## Engineers Comments Regarding Surface Water Drainage

<b>Application Reference:</b>	BN/46/25/PL	<b>Reviewer Reference:</b>	ADC/SB
<b>Planning Officer:</b>	Amber Willard	<b>Date of Review:</b>	06/08/2025
<b>Site Name:</b>	Land South of Wandleys Lane Eastergate PO20 3SE		
<b>Application Description:</b>	Application for construction of 10 No. dwellings with new access from Wandleys Lane, landscaping and areas for ecology & amenity space. This application is a Departure from the Development Plan and is in CIL Zone 3 and is CIL Liable as new dwellings.		
<b>Assessment Number:</b>	1 of 1

<b>Response</b>	<b>No objection subject to condition.</b>
-----------------	---

Drawing Code	Drawing No.	Rev.
000-BPC-WD-ZZ-D-C	PL005	P00

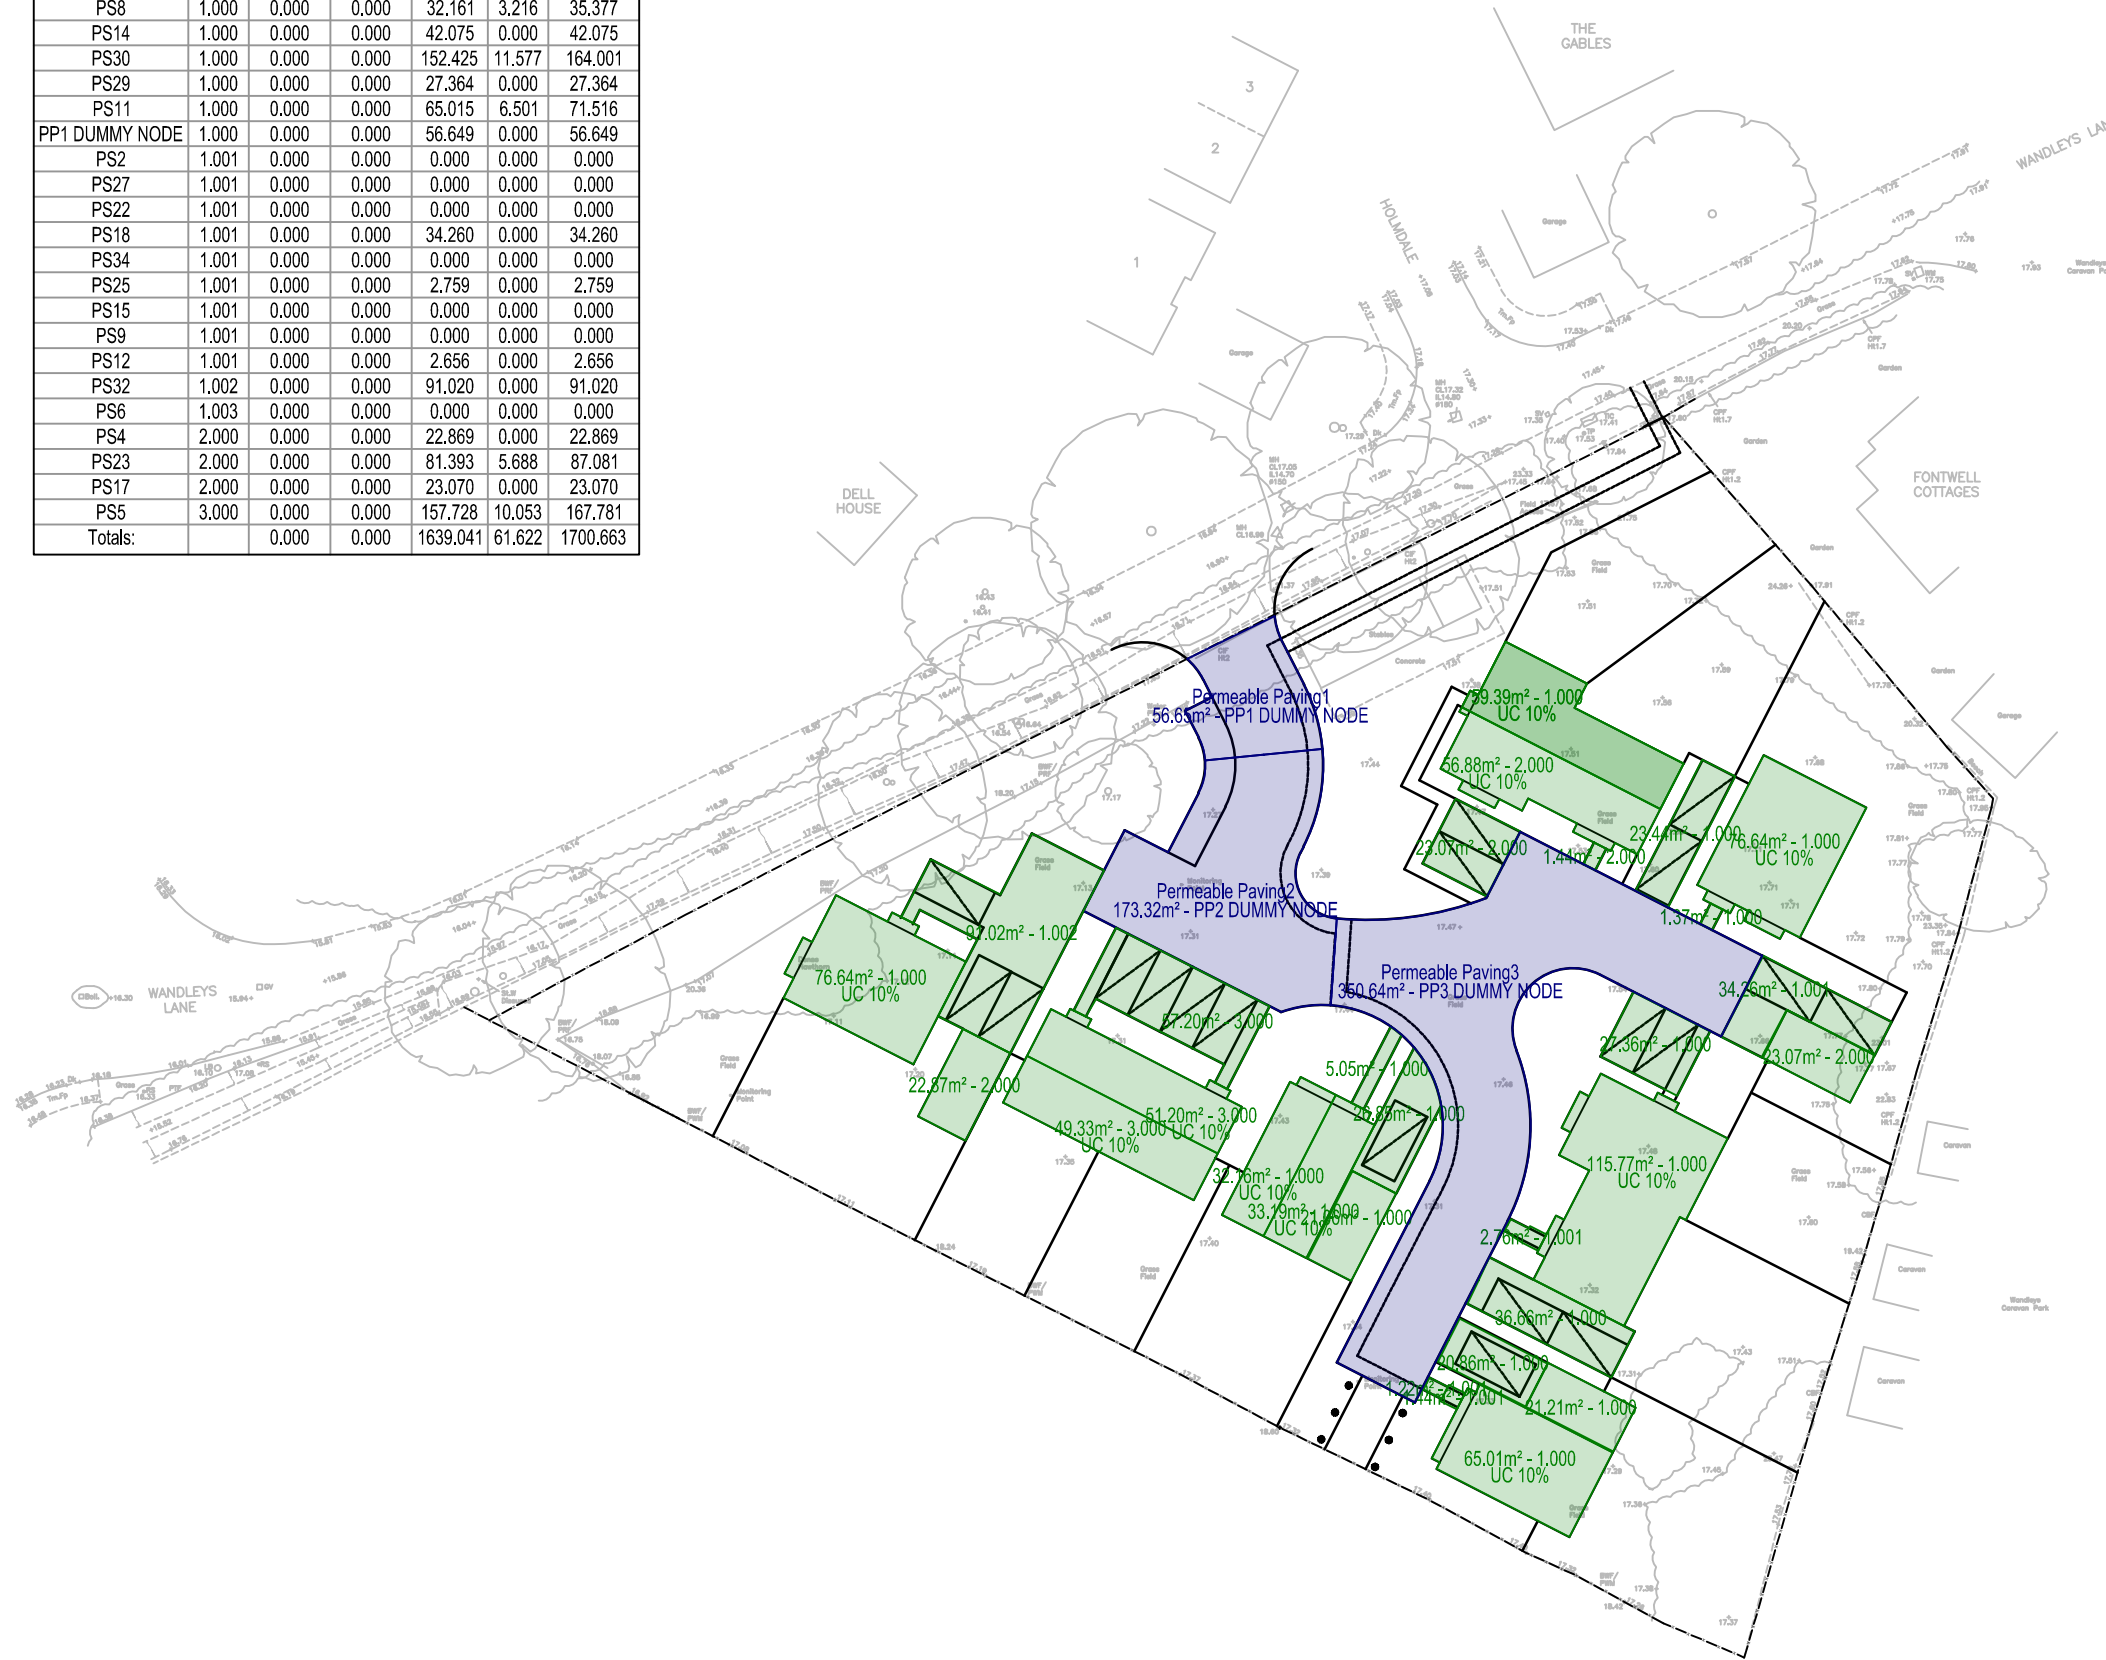
<p><b>Calculations</b></p>	<p>Calculations for pre-development run off rates must be based upon the positively drained area only.</p> <p>Proposed discharge rates must not increase flood risk on site or elsewhere. Discharge rates must be restricted to QBAR or 2 l/s/ha, depending on whichever is higher.</p>	<p><b>Not assessed</b> – due to infiltration design</p>
	<p>Designs must be based on the most recently available rainfall data at the time of conditions being applied. <b><u>FSR rainfall data will not be accepted.</u></b> FEH rainfall data is based upon more recent records and continues to be updated.</p>	<p><b>Compliant</b></p>
	<p>Designs must use the correct climate change allowances at the time of determination of the outline or full planning application.</p> <p>CV values for all events must be set to 1. This includes summer, winter, design, and simulation events.</p> <p>The correct allowance for urban creep must be applied.</p> <p>Additional storage must be set to zero unless it can be evidenced where this is provided.</p> <p>Infiltration half-drain times must be less than 24 hours.</p> <p><b>Infiltration design rates must be applied to the sides of soakaways, or to the base of infiltration blankets. Design rates must not be applied to both the base and sides of infiltration structures.</b></p> <p><del>A surcharged outfall must be modelled.</del></p>	<p><b>Insufficient</b> – unclear where the design rate is applied on the modelling – to be clarified via condition.</p>

<p>Appropriate easements to watercourses and other services must be shown on all plans.</p> <p>Where there are areas of flood risk from any source on the site, it must be shown how a sustainable surface water drainage design can be accommodated on the site without conflicting with those areas of flood risk.</p> <p>Designs must replicate the natural drainage catchments of the site. All surface water drainage designs must therefore drain via gravity to corresponding points of discharge.</p> <p><b>The use of pumps for surface water drainage is not sustainable and will only be considered where the designer has fully demonstrated that they are proposed as a last resort.</b></p>	
<b>Plans</b>	Plan areas, depths and levels of drainage infrastructure must accurately correspond with the supporting calculations.	<b>Insufficient</b> – the contributing areas have not been fully modelled. Only 1500m <sup>2</sup> is accounted for in the modelling (of 1737m <sup>2</sup> ).
